Our ref: AC/2021/130634/02-L01
Your ref: TR010044
Date: 14 January 2022

A428 BLACK CAT TO CAXTON GIBBET ROAD IMPROVEMENT SCHEME THE EXAMINING AUTHORITY'S 3RD WRITTEN QUESTIONS

Thank you for your correspondence regarding the above mentioned scheme. Our answer to your questions are provided below.

Plot Date: 14 December 2021 11:16:15  
 File Name: C:\Users\jgibbet\Documents\HE551495-ACM-HGN-ZN2\_SW\_Z\_ZZ-DR-CD-0006

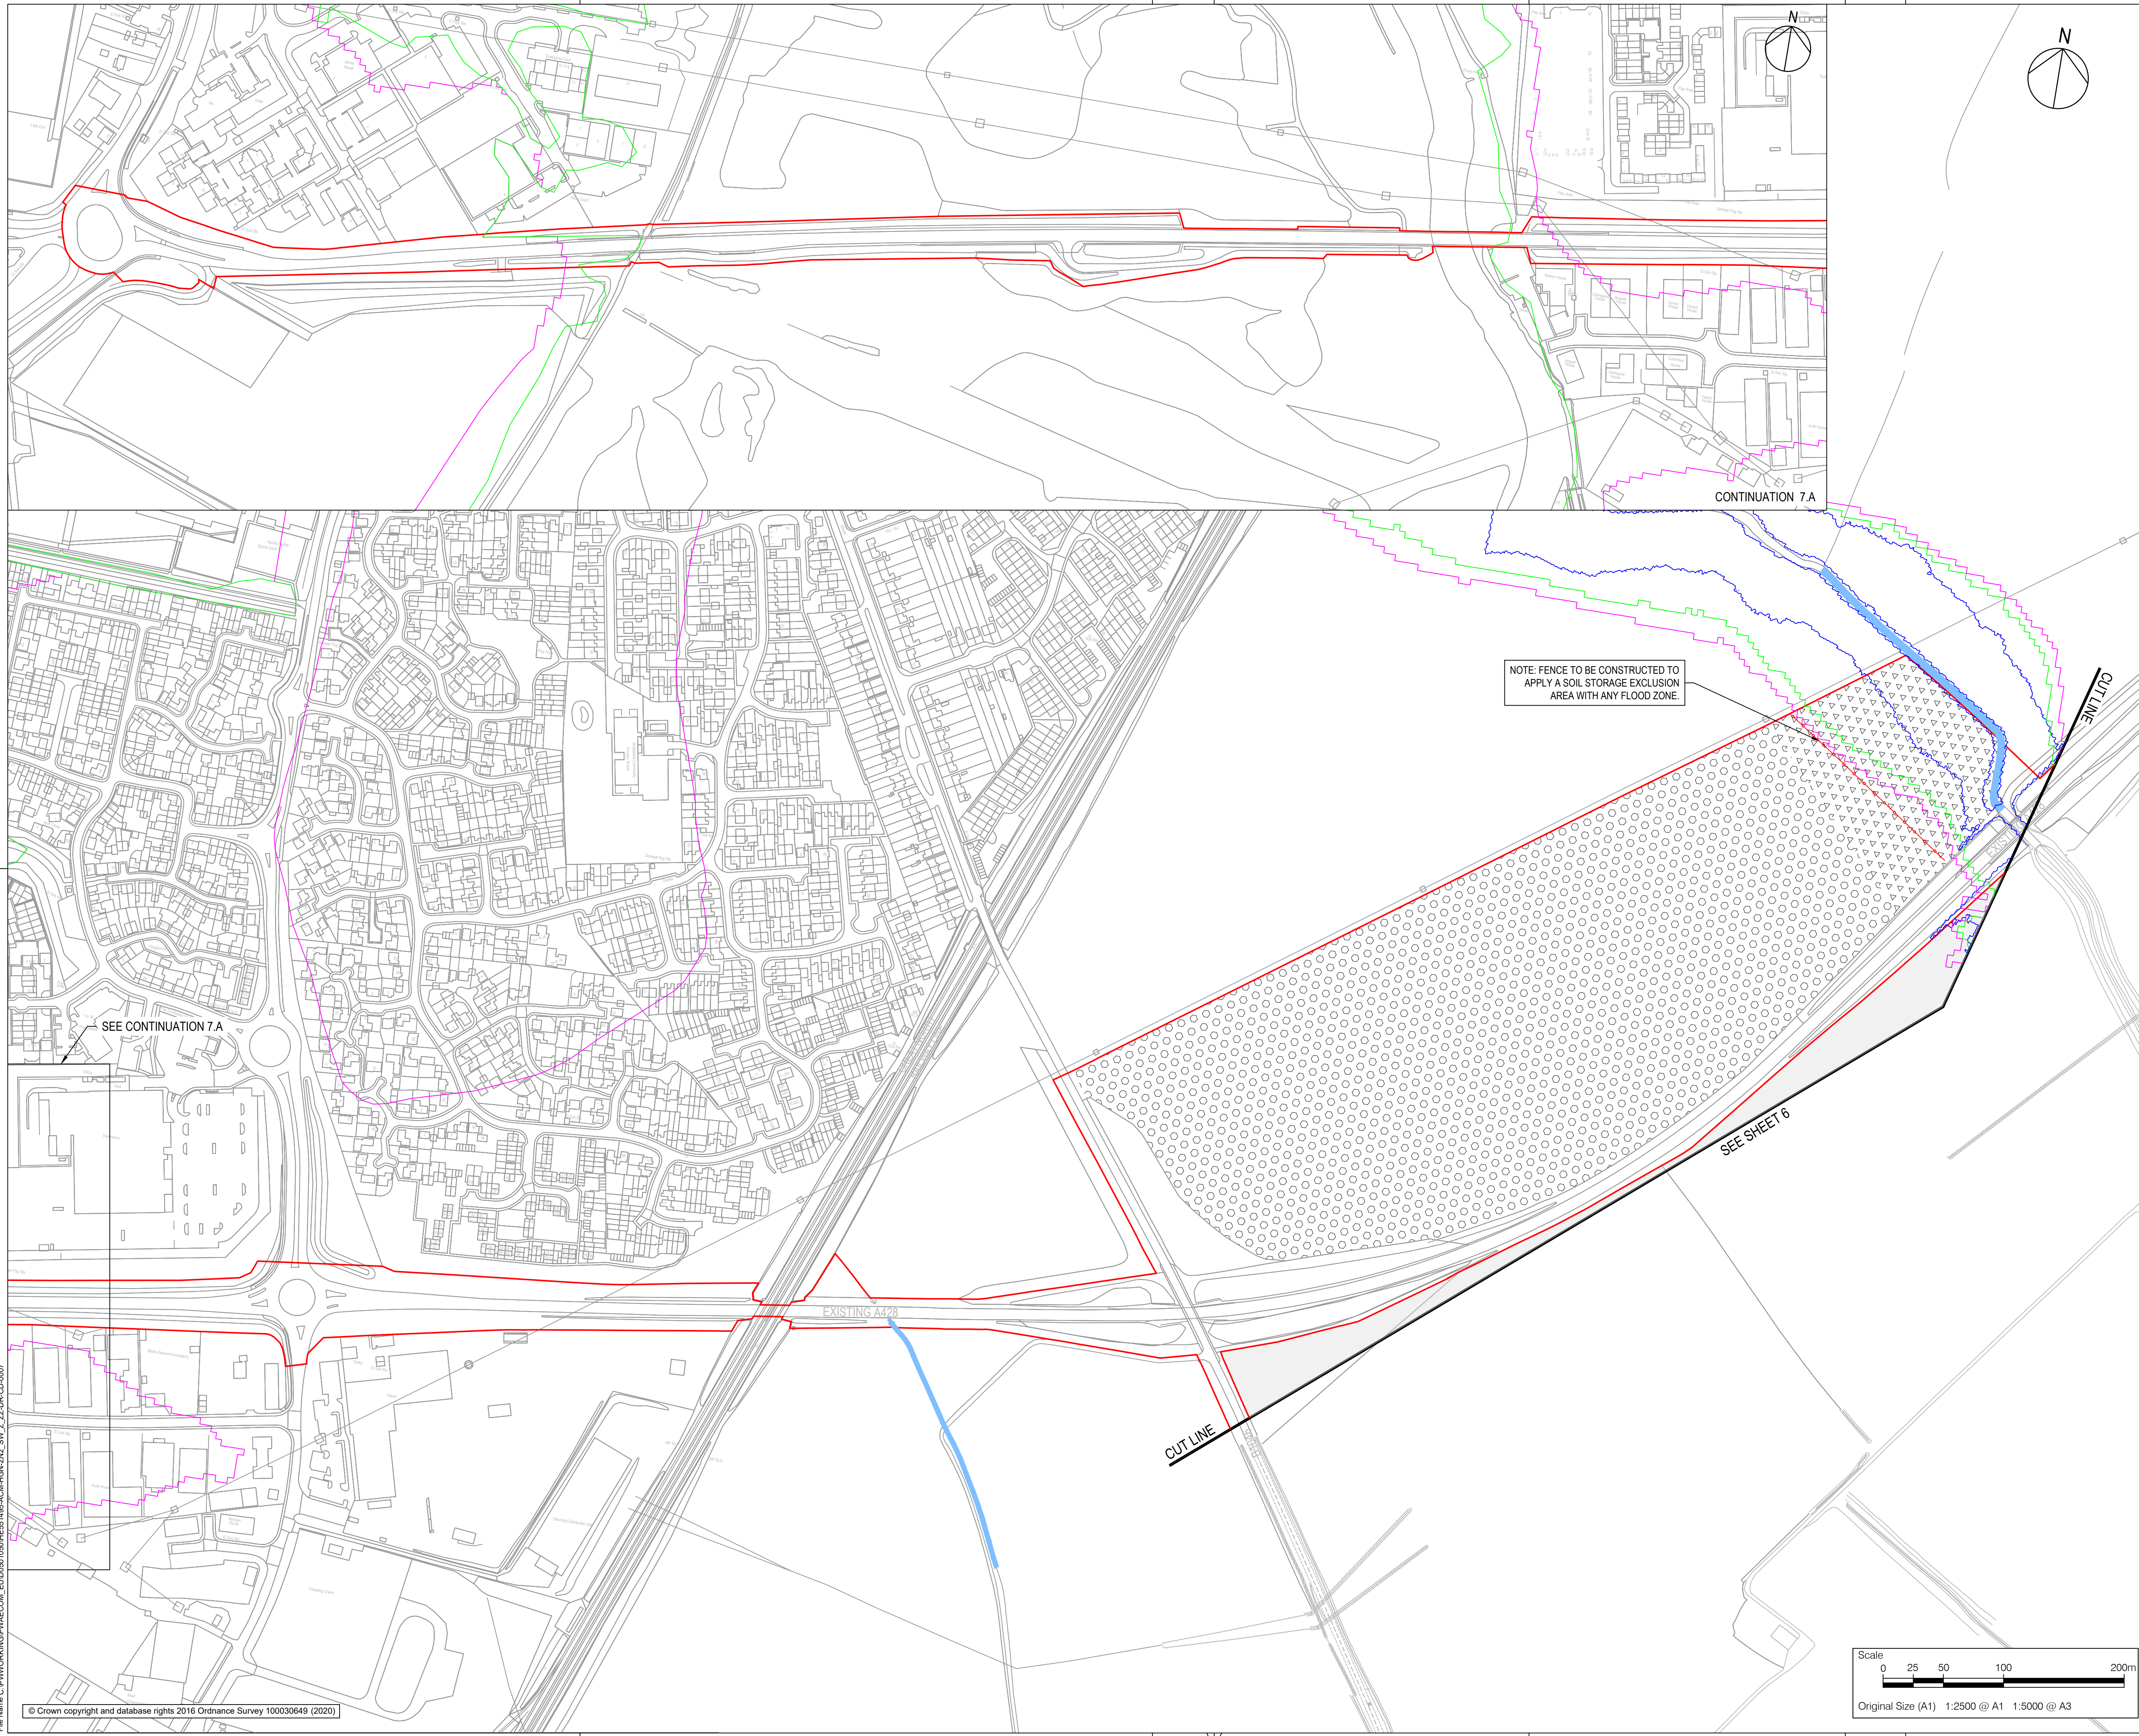
Given that one of the site compound areas is shown to be located entirely within Flood Zone 3 in Appendix B of the FRA Technical Note dated December 2021, we would like the First Iteration EMP to include some mitigation measures in relation to this to ensure there is no increase in flood risk elsewhere during the construction phase.

The First Iteration EMP (sections 1.737, 1.738, 4.2.28 and 4.2.29) states that no hazardous materials (COSHH) will be located in Flood Zone 3 (area at highest risk). However, Appendix B of the Flood Risk Assessment (FRA) Technical Note dated December 2021 still shows a number of site compound and soil storage areas within Flood Zone 3 and some of these are immediately adjacent to watercourses where we would expect flood water to regularly flow and be stored. We therefore consider that no soil storage areas or site compounds should be located within Flood Zone 3.
